SCOPING OPINION:

Proposed Hedgehog Grove Solar Farm

Case Reference: EN0110021

02 June 2025

Figure 8.1
Ecological Statutory Designated Sites
Scoping Report
Hedgehog Grove Solar Farm

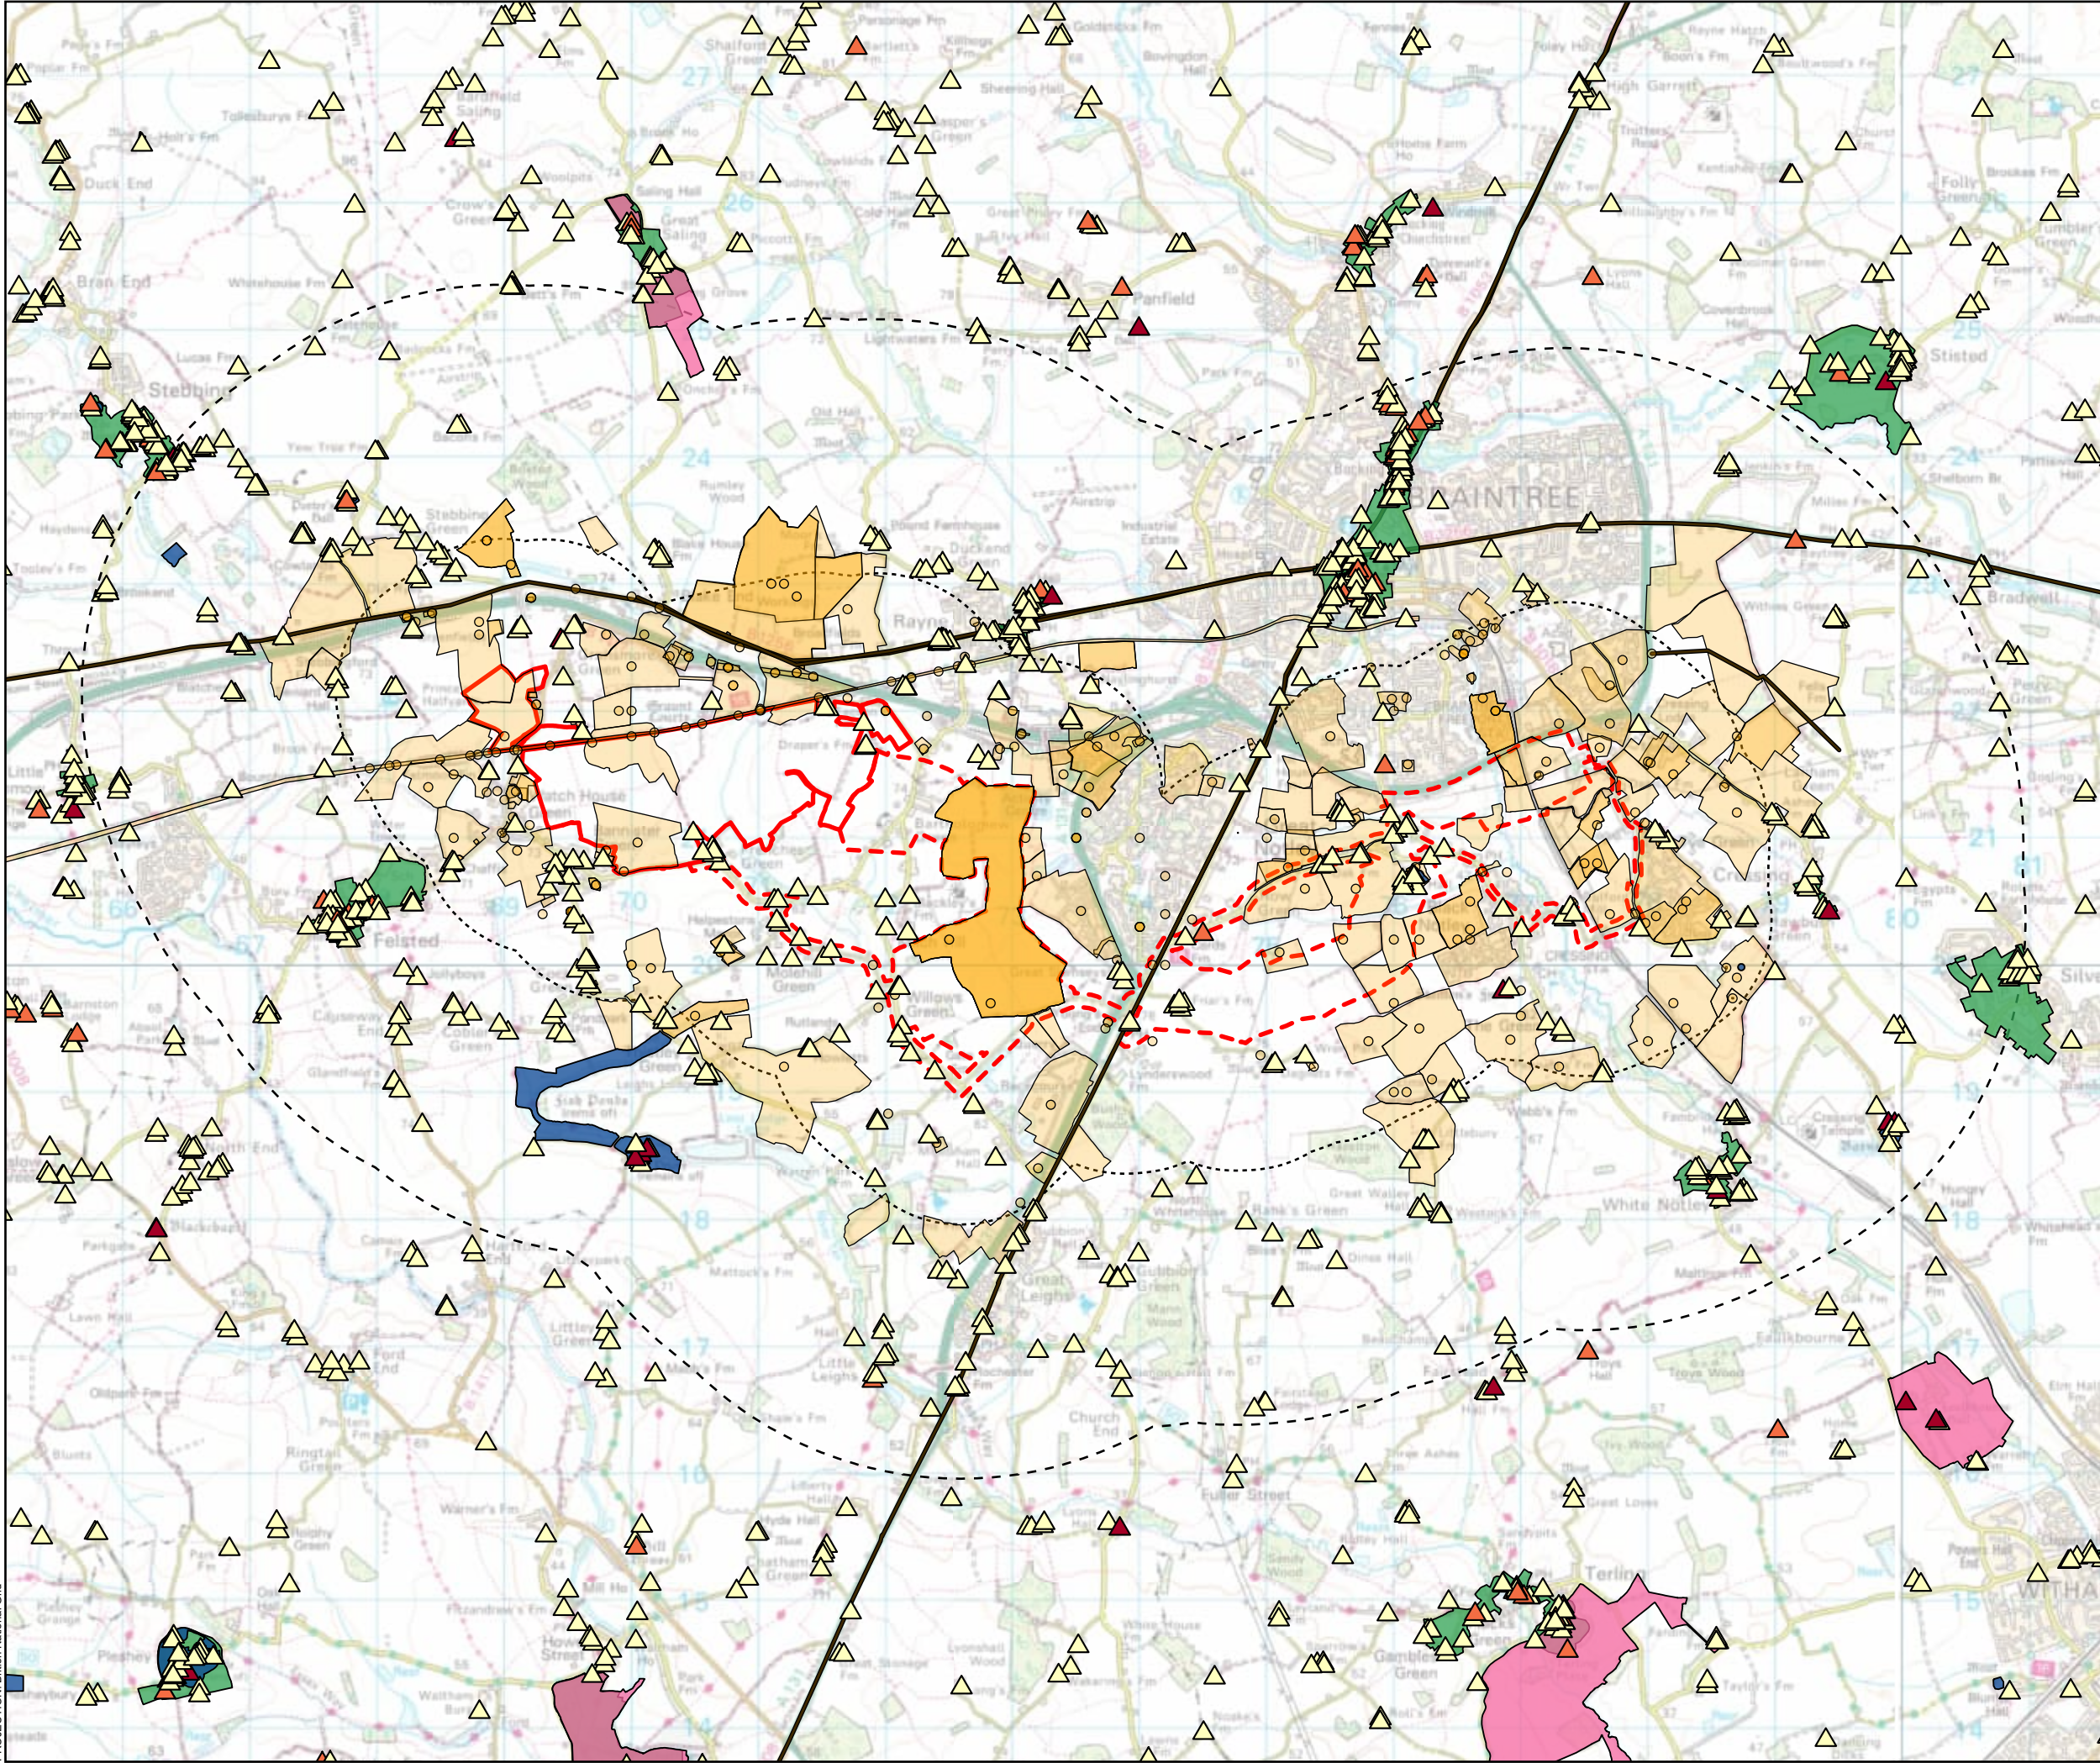
ID	Ref	Description	Inspectorate's comments
			figures. For example, paragraph 8.3.10 of the Scoping Report refers to figure 8.1 but should refer to figure 8.2. The applicant should make efforts to ensure that there are no presentation errors within the ES.
